ACCESS REPORT

DEVELOPMENT APPLICATION

“SITE 9”

**3 OLYMPIC BOULEVARD
CNR SARAH DURACK AVENUE
SYDNEY OLYMPIC PARK**

Drawing no. **DA02.001** Revision **A**

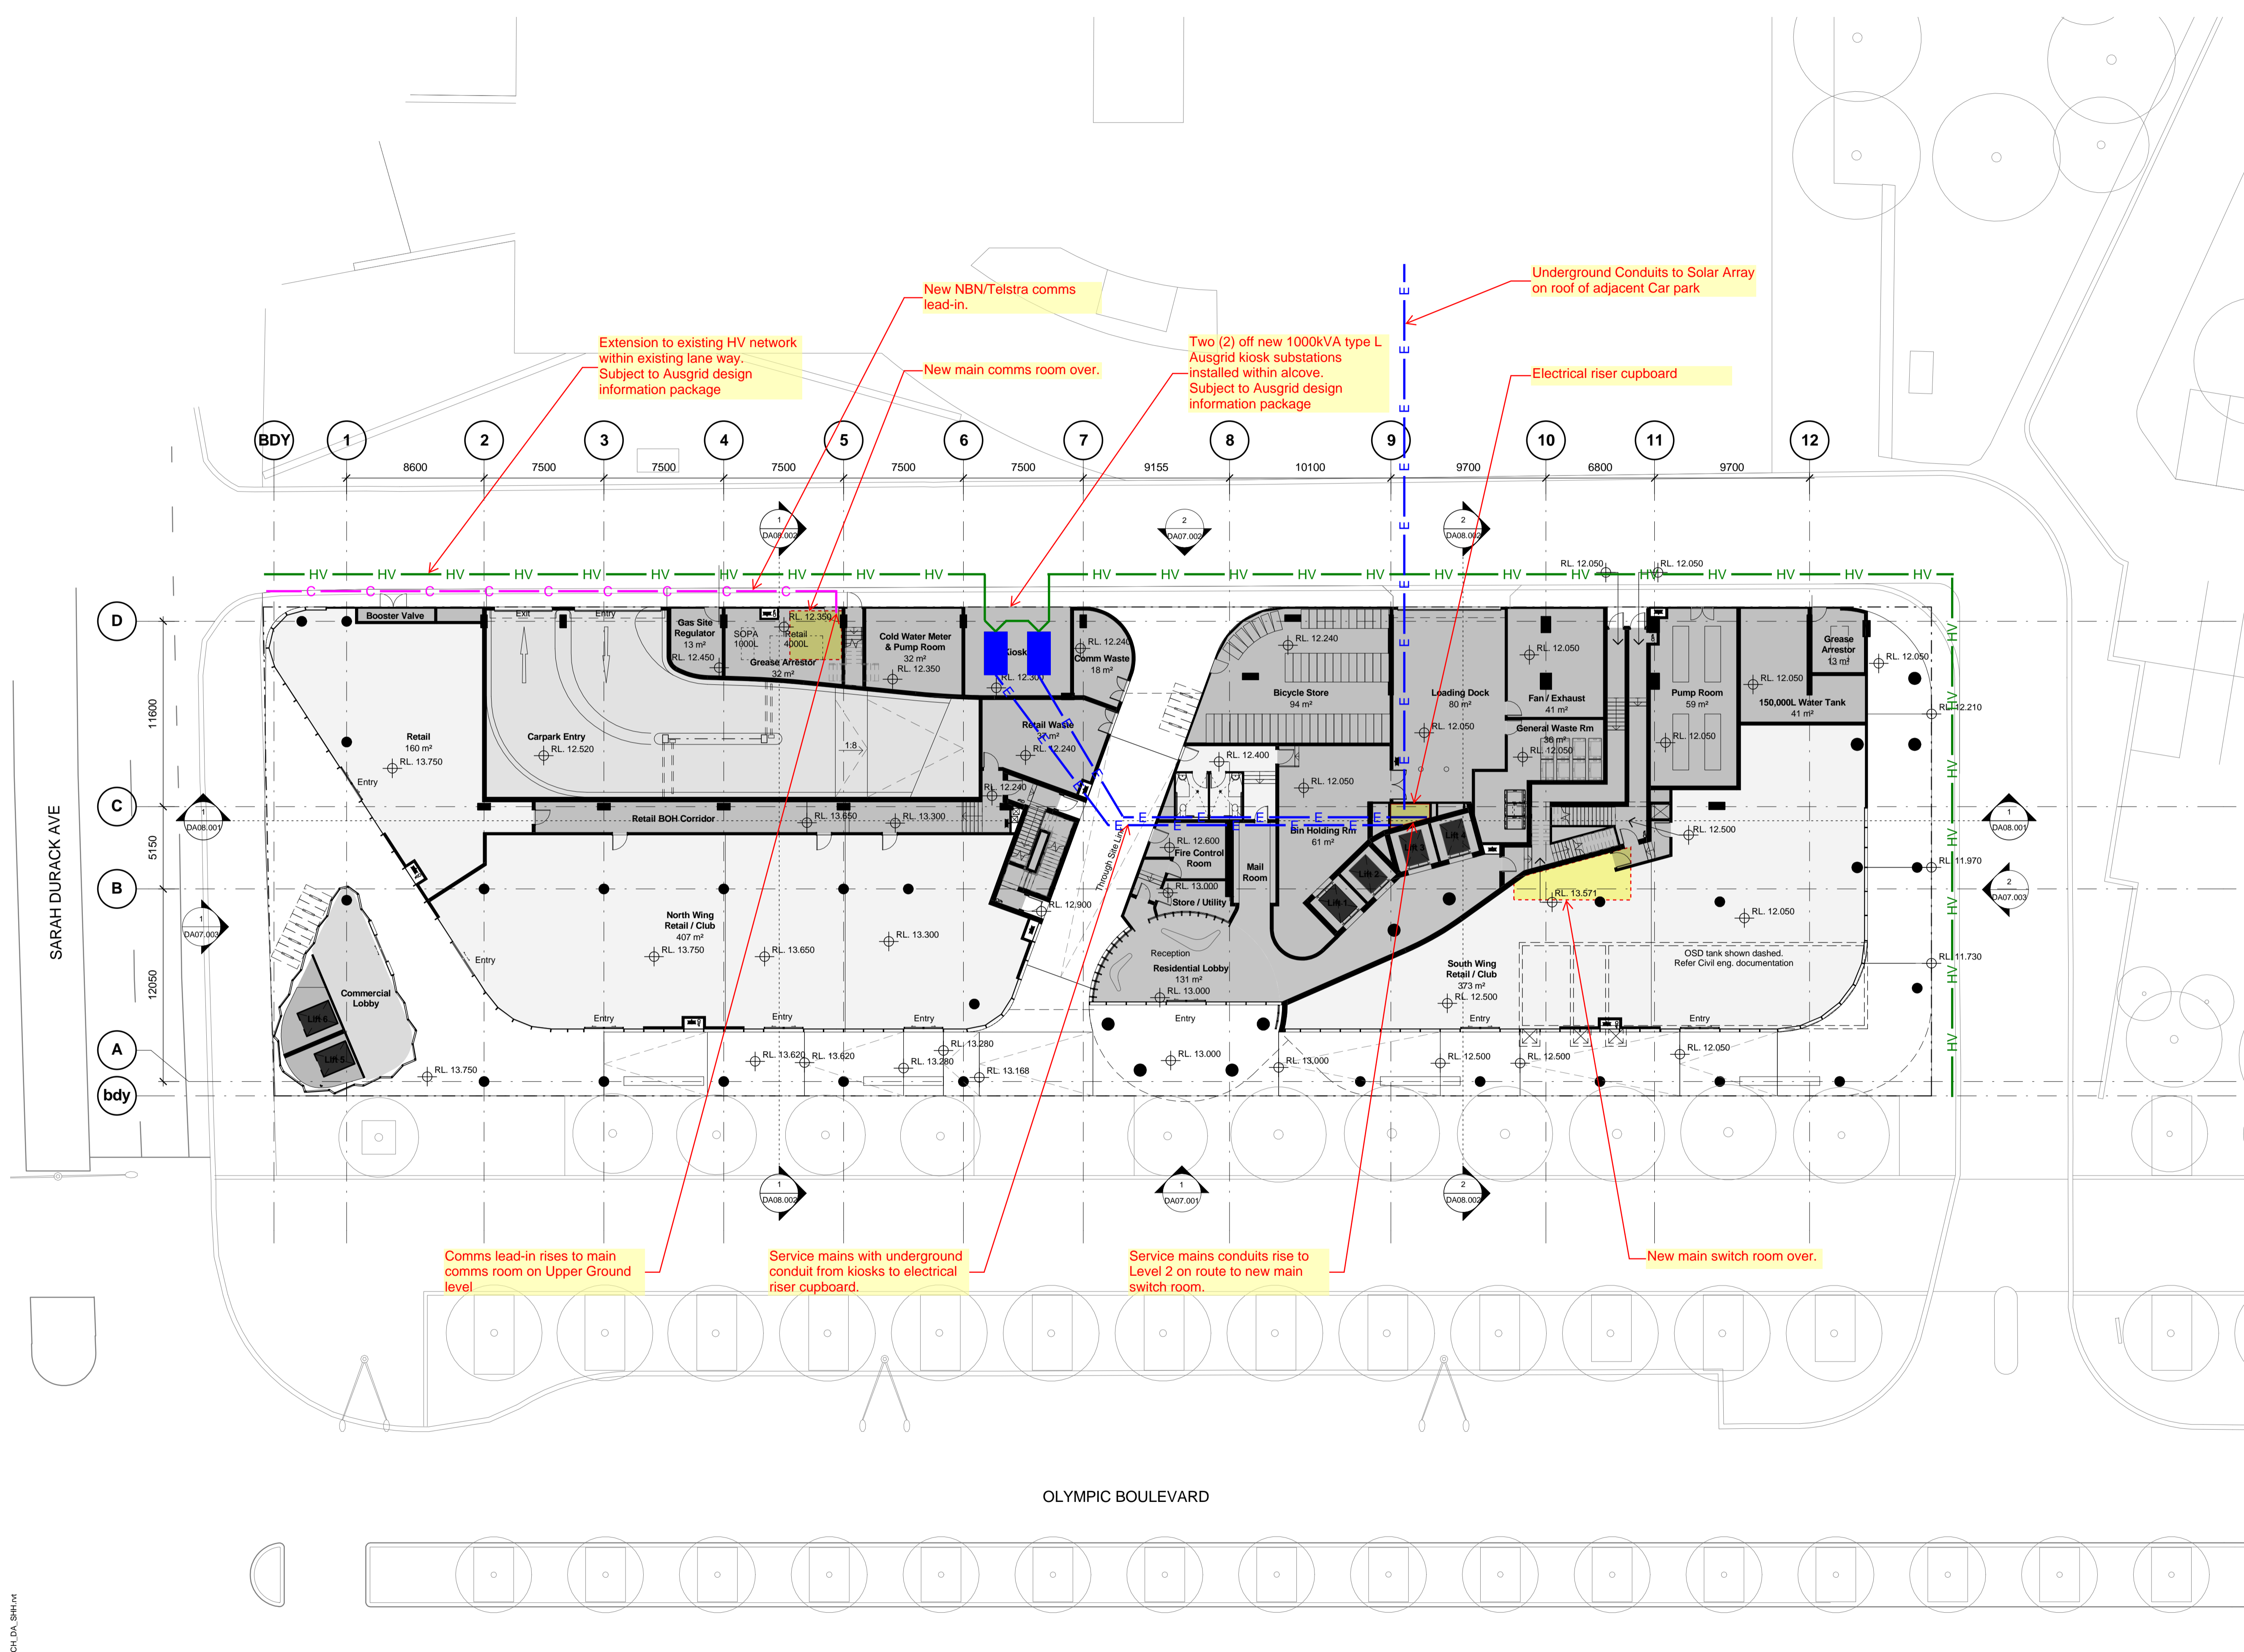
BCA / DDA Access Code Review		Complies
1. Retail Entrances – The development proposes several retail tenancies on the ground floor at varying finished floor levels which reflect the topography of the adjacent public domain footpath along the Olympic Boulevard to enable level doorway thresholds to ensure equitable access to and within all areas consistent with the DDA Premises Standards and Part D3.2 of the BCA.		YES

3. Commercial Entry Lobby – The development proposes a level threshold entrance to the common residential lobby through an auto sliding doorway which facilitates universal access that complies with AS1428.1 to satisfy D3.2 and Table D3.1 of the BCA and the SOP Access Guidelines.		YES

4. Common Residential Entry Lobby – The development proposes a level threshold entrance to the common residential lobby @RL13.00 through an auto		YES

8. Through Site Link – The development proposes a public through site link that will provide a moderate 1:20 slope from RL21.900 to RL12.400 and will facilitate access to the common accessible toilets and bike storage room and subject to a minor adjustment of the walkway to ensure a 510mm minimum offset from the common toilets access door then the through site link will fully comply with AS1428.1 and satisfy Part D3.3 of the BCA, DDA Premises Standards and the SOP Access Guidelines.	YES

9. Common Area Accessible Toilets - In addition to the provision of accessible principal building entrances the development proposes common sanitary facilities on the ground floor that can be accessed by all retail tenancies and visitors to the residential component of the development. The plans show two wheelchair accessible toilets that will comply with AS1428.1 and satisfy Parts D3.3, F2.4 of the BCA, DDA Premises Standards and the SOP Access Guidelines.	YES

18. Common Area Accessible Toilets - The development proposes two wheelchair accessible common toilets on the ground floor that can be accessed by all retail tenancies and visitors to the residential component of the development, albeit the accessible pathway is external to the building. The two toilets will comply with AS1428.1 and satisfy Parts D3.3, F2.4 of the BCA, DDA Premises Standards and the SOP Access Guidelines.		YES

Drawing no. **DA02.007** Revision **A**

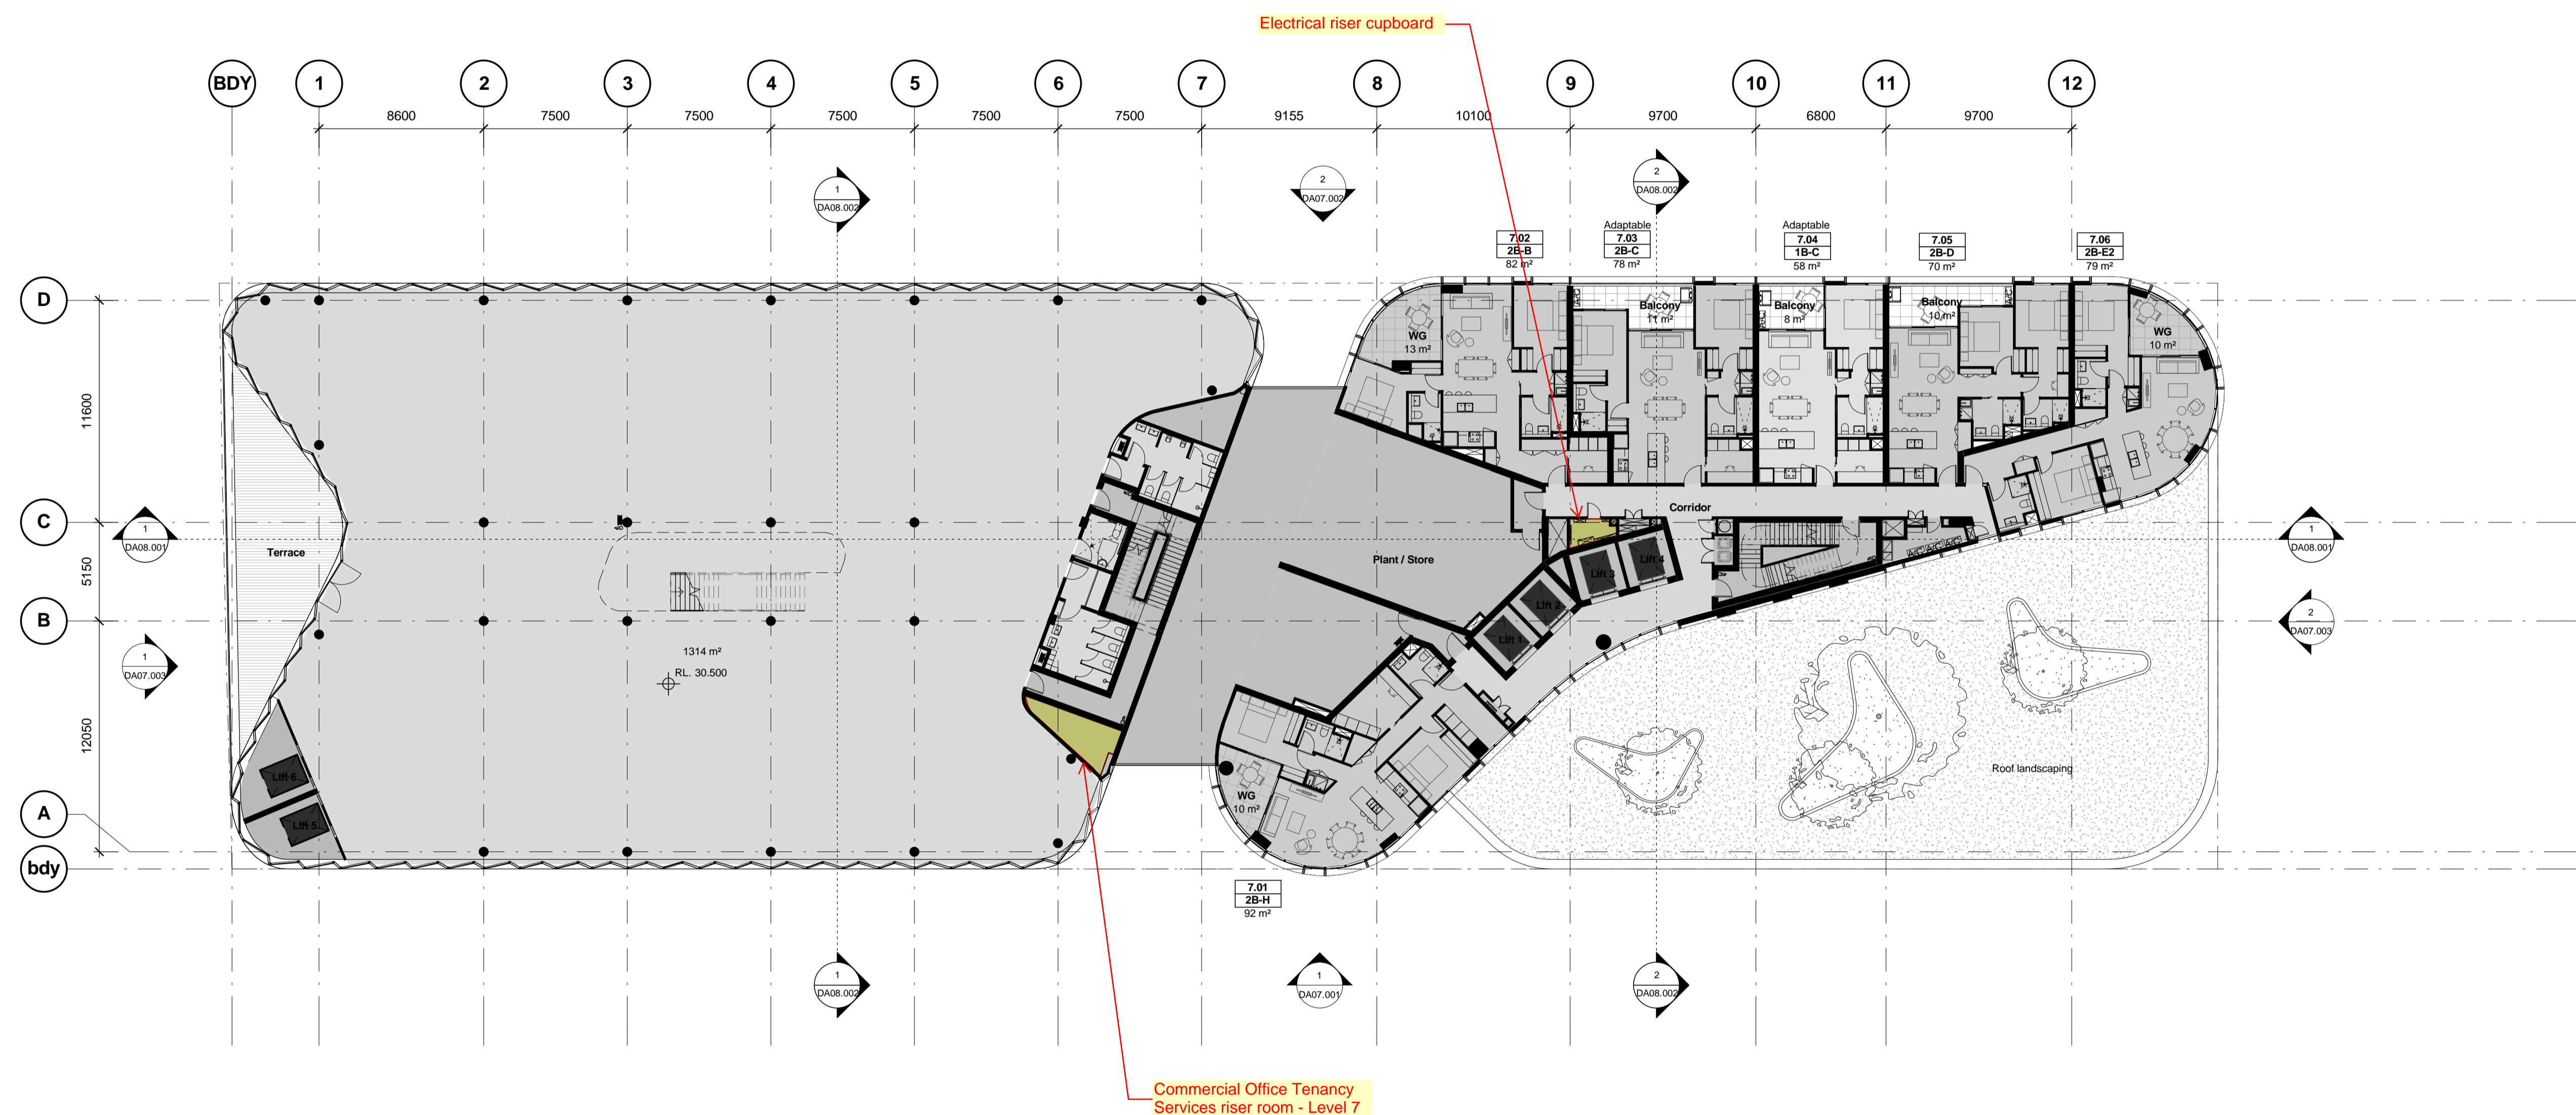
20. Level 7 & 8 Commercial tenancies can be directly accessed from the commercial lifts while the open plan layouts across a single level will enable access to all areas in accordance with AS1428.1 and satisfy Part D3.3 of the BCA, DDA Premises Standards and SOP Access Guidelines.	YES

21. Common Sanitary Facilities – Each floor proposes sanitary facilities that illustrate a unisex wheelchair accessible toilet and male and female toilets that can include ambulant accessible cubicles to comply with AS1428.1 and satisfy Part D3.3 of the BCA, DDA Premises Standards and SOP Access Guidelines.	YES at CC stage

Drawing no. **DA02.010** Revision **A**

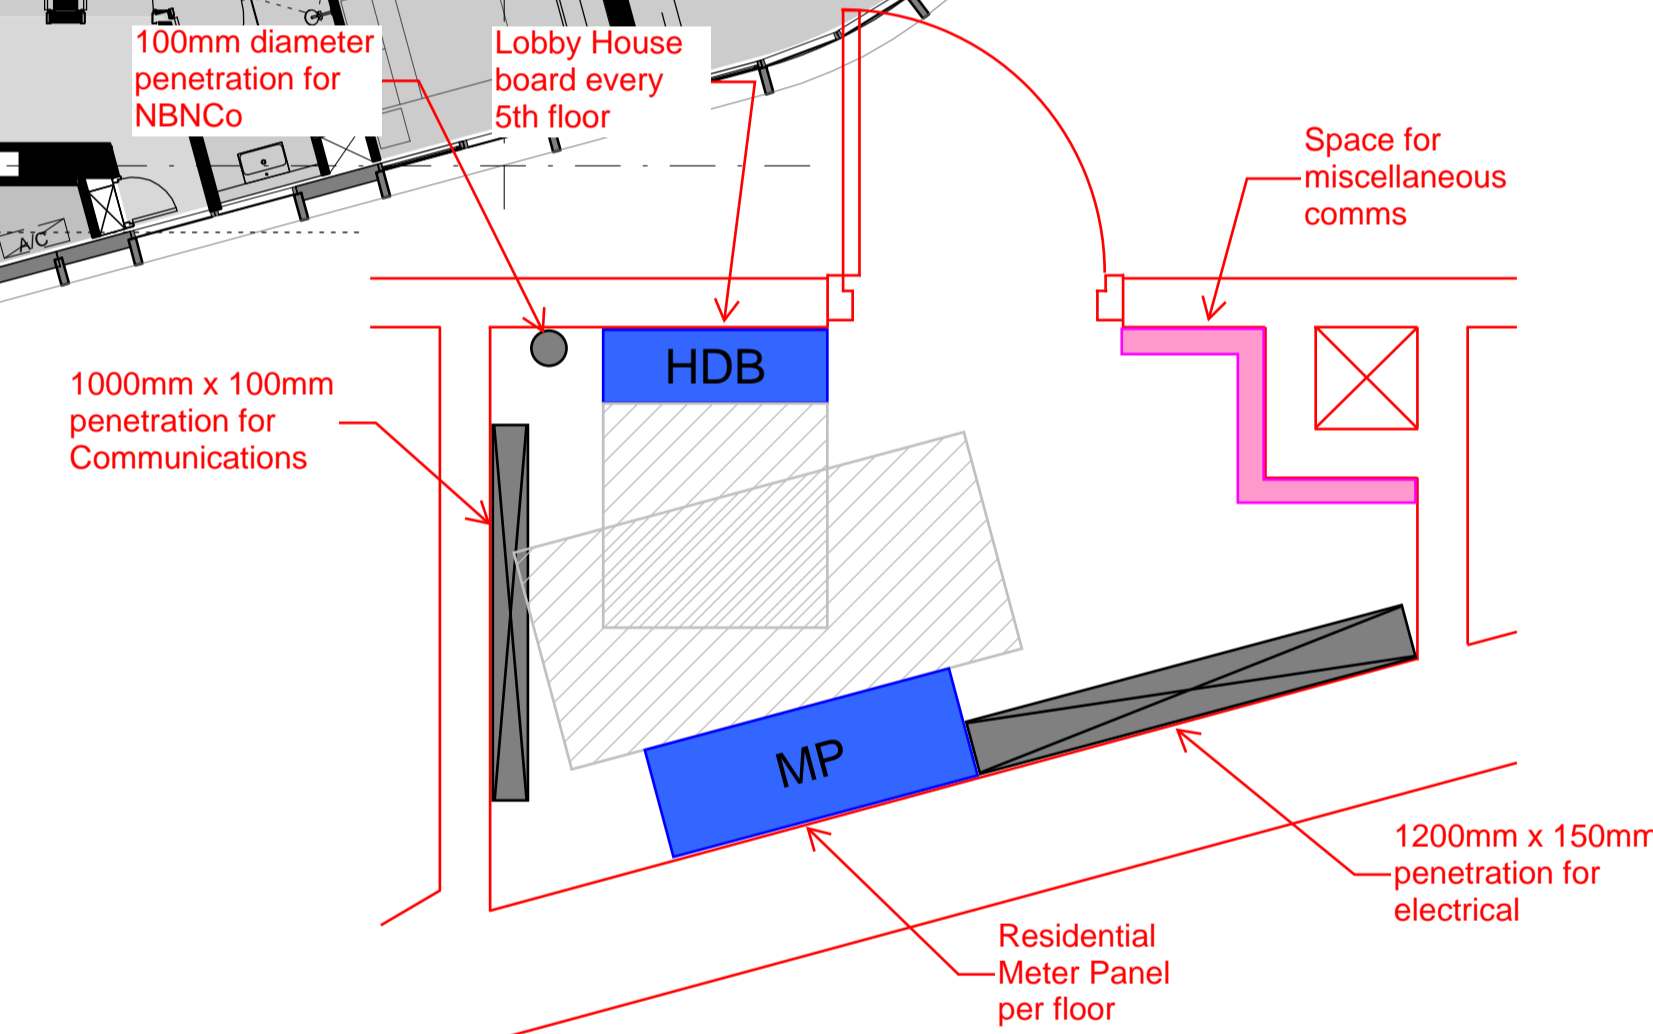
27. Common Area Access (Levels 7 to 38) – At levels 7 to 38 the plans propose ample circulation spaces at lift landings which are generally 1800-2200mm width with a 1690mm width area at a column between Lifts 2 and 3 which complies with AS1428.1 to satisfy Part D3.3 of the BCA and the SOP Access Guidelines.	YES

28. At the northern end of the lifts there corridor provides a 1200mm width pinch point while the end of the corridor has a 1600mm X 2070mm Turning Area and appropriate access to the apartment entrance doorways.	YES

36. Garbage Disposal – Throughout the residential apartment levels the plans propose garbage chutes directly adjoining 1600mm minimum width corridors which enables appropriate access to the bin chute hatch door in accordance with AS1428.1 to satisfy part D3.3 and Table D3.1 of the BCA the SOP Access Guidelines.		YES
